DECISION DELEGATED TO HEAD OF PLANNING**DECISION DELEGATED TO HEAD OF PLANNING**

Application No: H02-1049-24 **Applicant:** Mr A Fasae & Mr G Lawal

Proposal: Details of contamination of land or pollution of controlled waters, landscaping, tree planting, proposed boundary treatments, external materials and window frames (Conditions 3, 8, 9, 10 and 11 of H02-0151-24)

Location: Land Off Hereward Way Crowland Peterborough

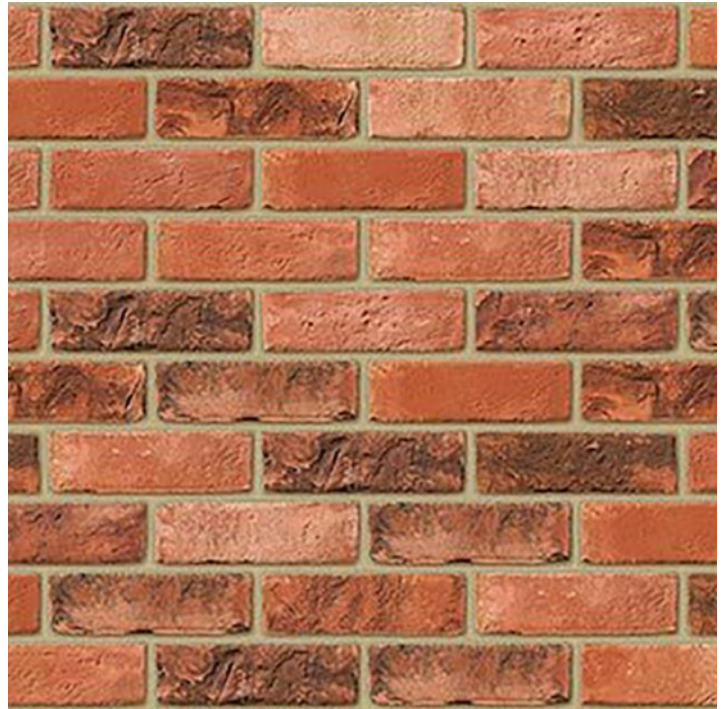
Whilst the tiles, brick work and surfacing arrangements are acceptable, the use of UPVC openings and door as not acceptable within the conservation area. The condition cannot therefore be discharged.

title
FLUSH SASH WINDOW DETAILS

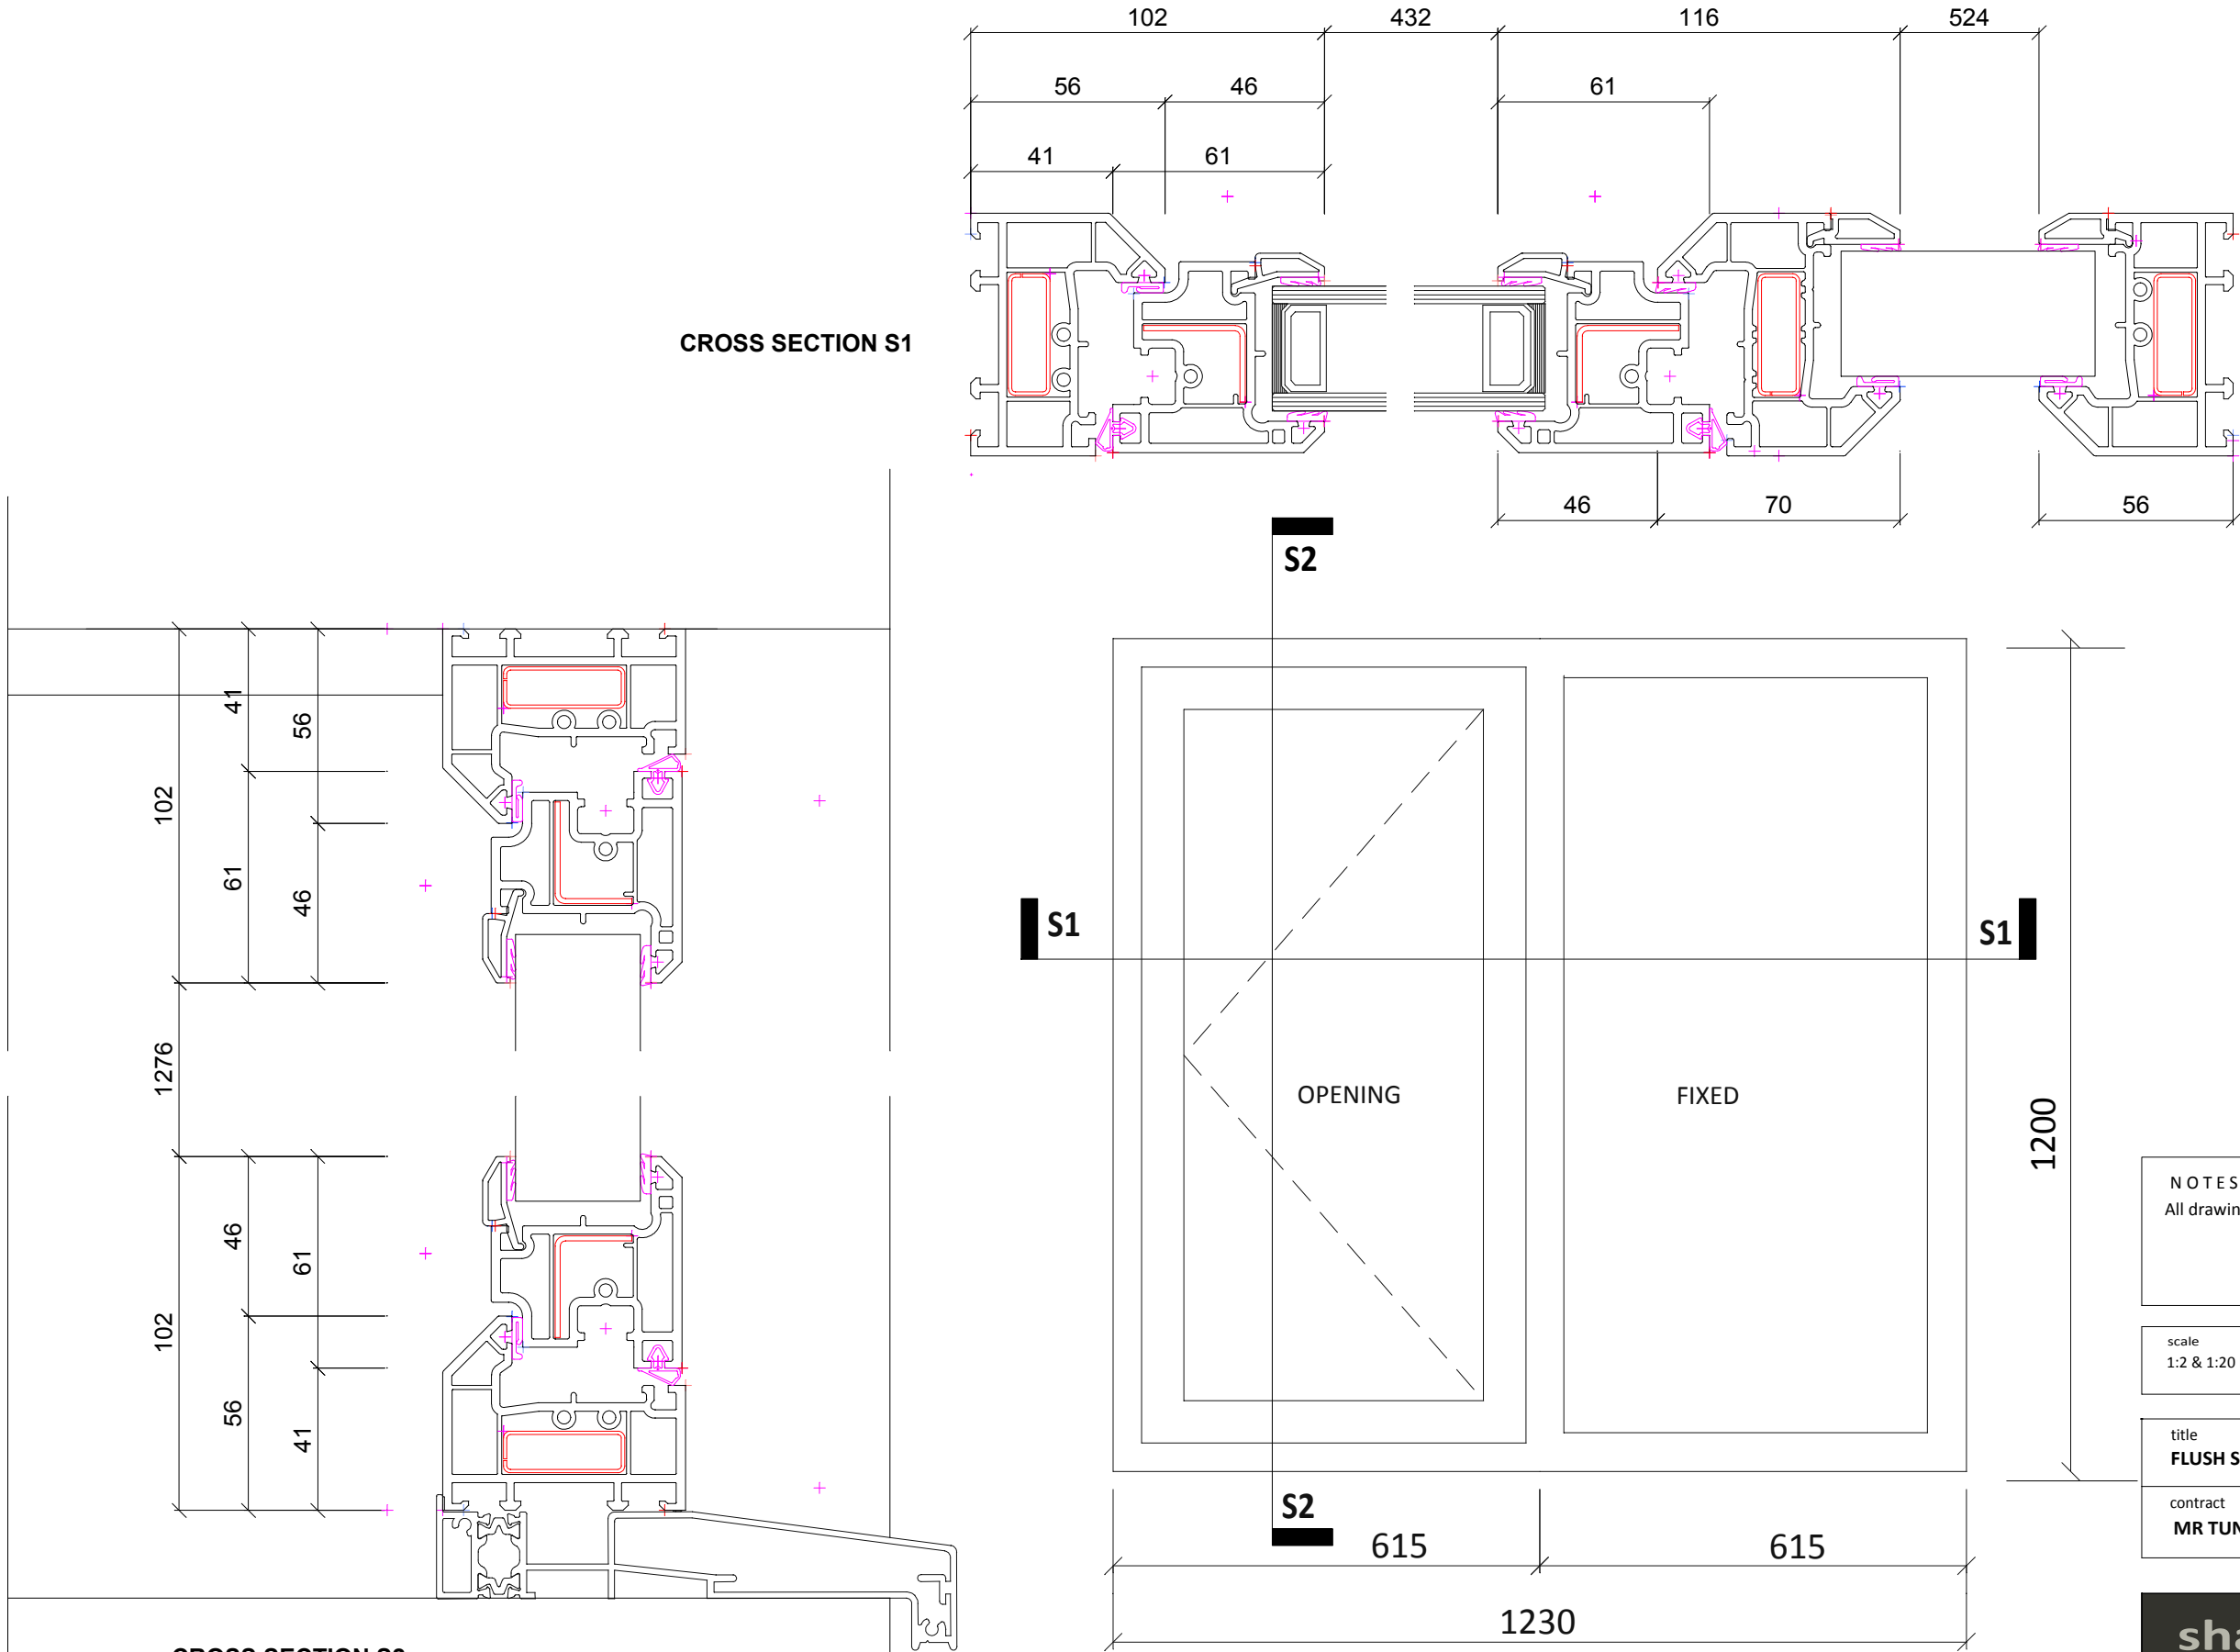
The use of UPVC is not considered acceptable in this location and therefore the condition cannot be discharged
